**A57 Link Roads**

**TR010034**

**Draft Statement of Common Ground with  
High Peak Borough Council**

## **8.2 DRAFT STATEMENT OF COMMON GROUND WITH HIGH PEAK BOROUGH COUNCIL**

**6.4 Environmental Statement
Figure 6.8 Zone of Theoretical Visibility With
Designated Heritage Assets - 1km**

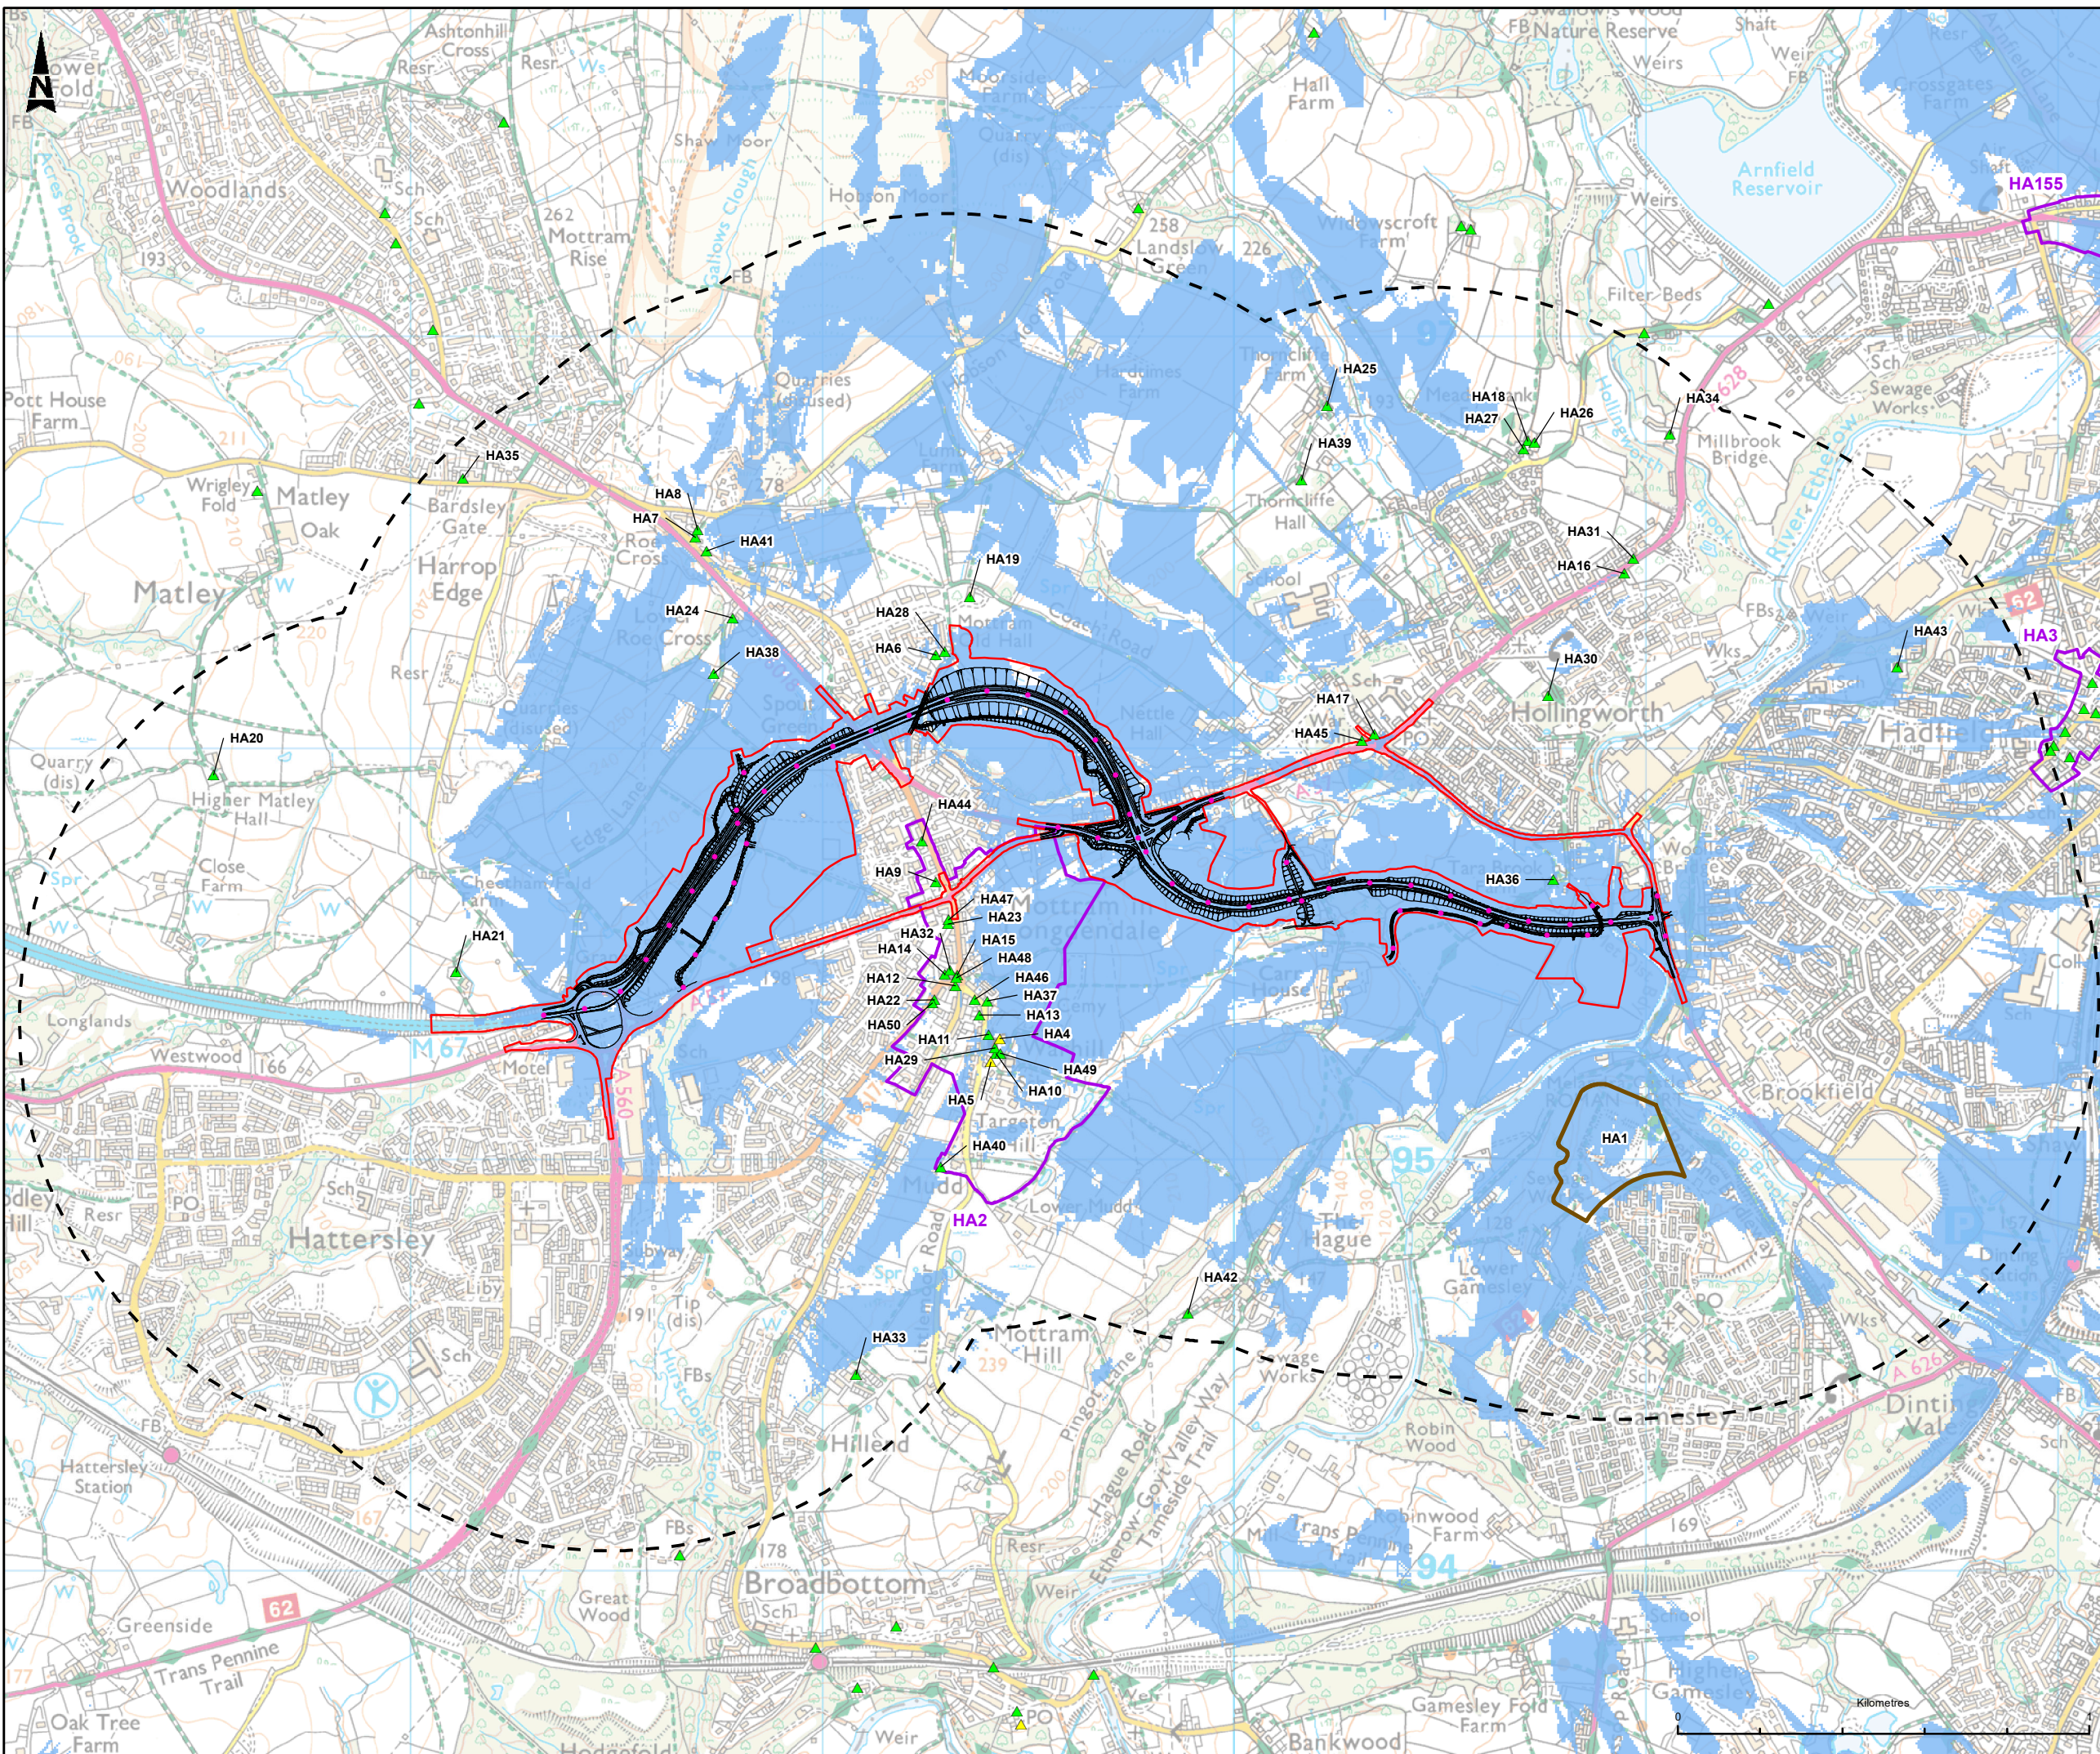
3.6	Environmental Statement (ES) [APP-062]	Archaeology & Cultural Heritage Methodology Melandra Castle	It indicates that the assessment of setting impacts to Melandra Castle should comprise a setting study following the five-step principle established in Historic England guidance and include appropriate viewpoint photography/ photomontages to show the potential impacts of the development.	The Applicant undertook the assessment in relation to this guidance.	Agreed

SoCG Ref. Number	Relevant examination document	Relevant Issue	HPBC Comment	National Highways response	Status
3.7	Environmental Statement (ES) [APP-062]	Archaeology & Cultural Heritage  Methodology  Melandra Castle	The Consultees stated it that it had requested additional viewpoints of Melandra Castle but could not see them within the consultation materials.	The Applicant stated that it currently had three representative Viewpoints in the vicinity of Woolley Bridge and Melandra Castle: a) View from the Woolley Bridge (A57) adjacent residential properties: b) View from Trans Pennine Trail c) View from PRoW HP12/72/3 adjacent Melandra Castle (SAM)	Agreed
